CITY OF ALBUQUERQUE

September 12, 2019

Site: Defined Fitness 8020 Central Ave. SW

Re: Drainage Ordinance (14-5-2-1) Violations for Erosion and Sediment Control

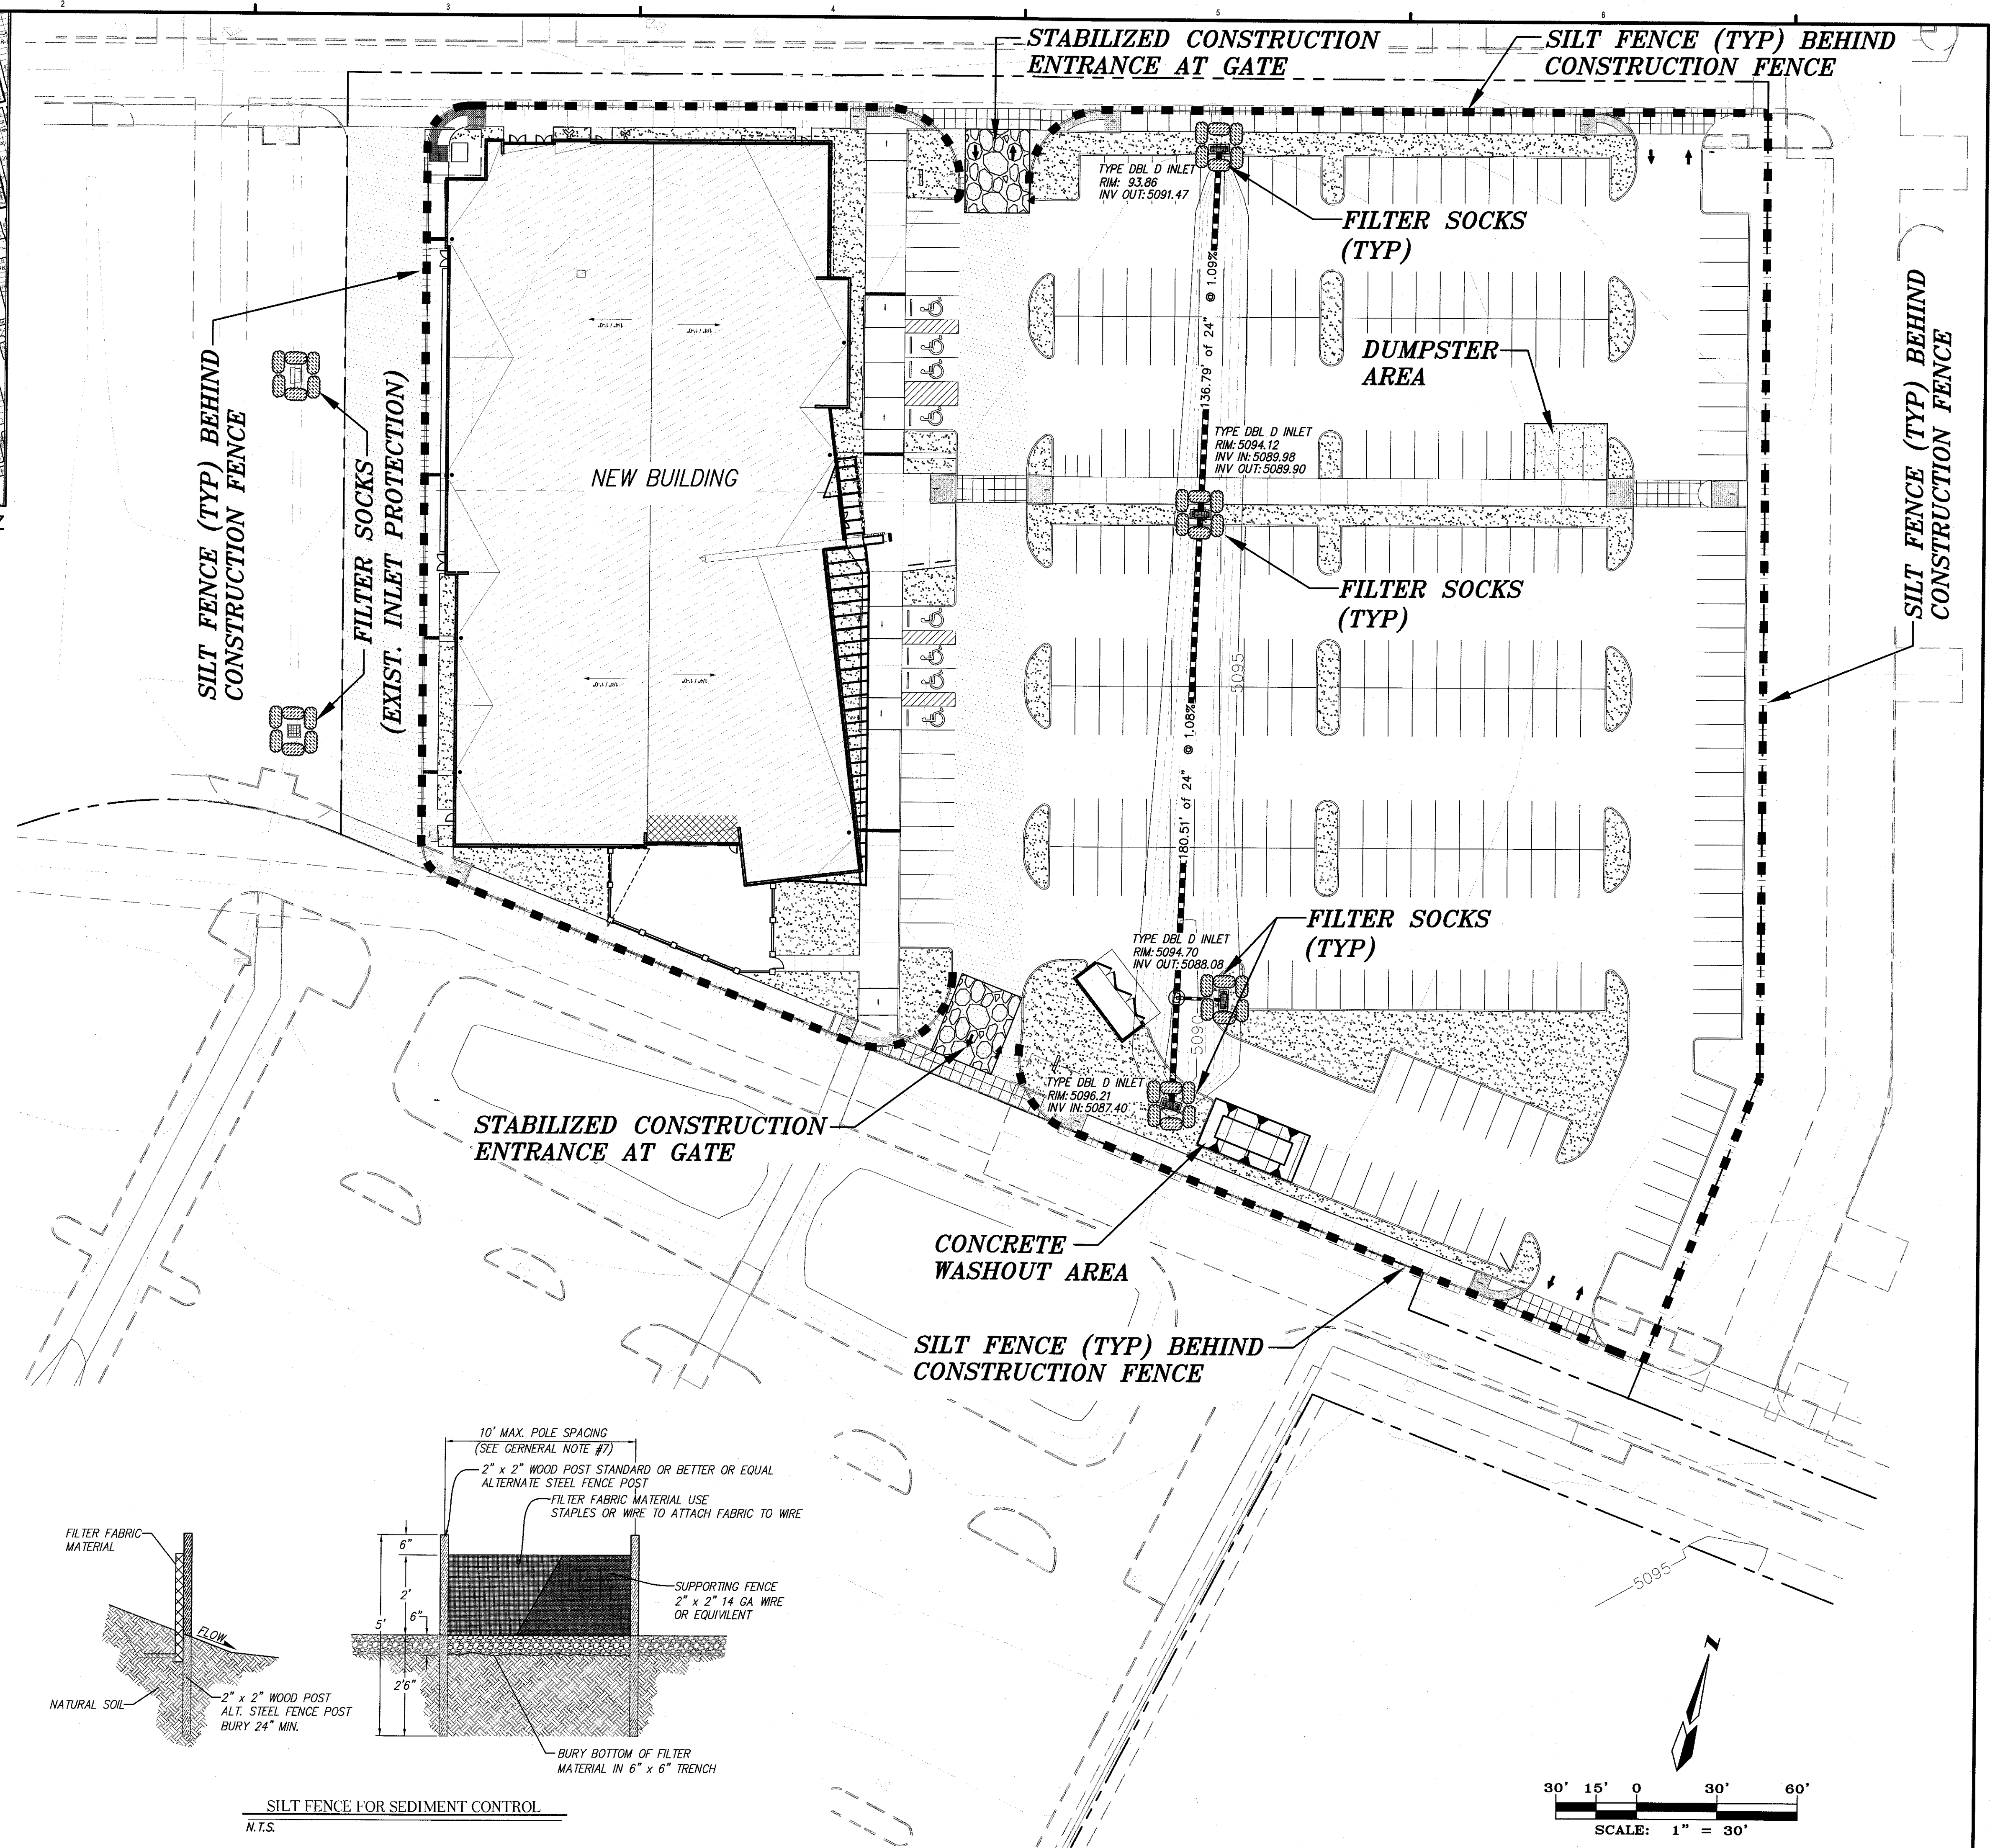
- Inlet Protection was missing from two onsite inlets.

Required Mitigation:

- Provide Inlet Protection
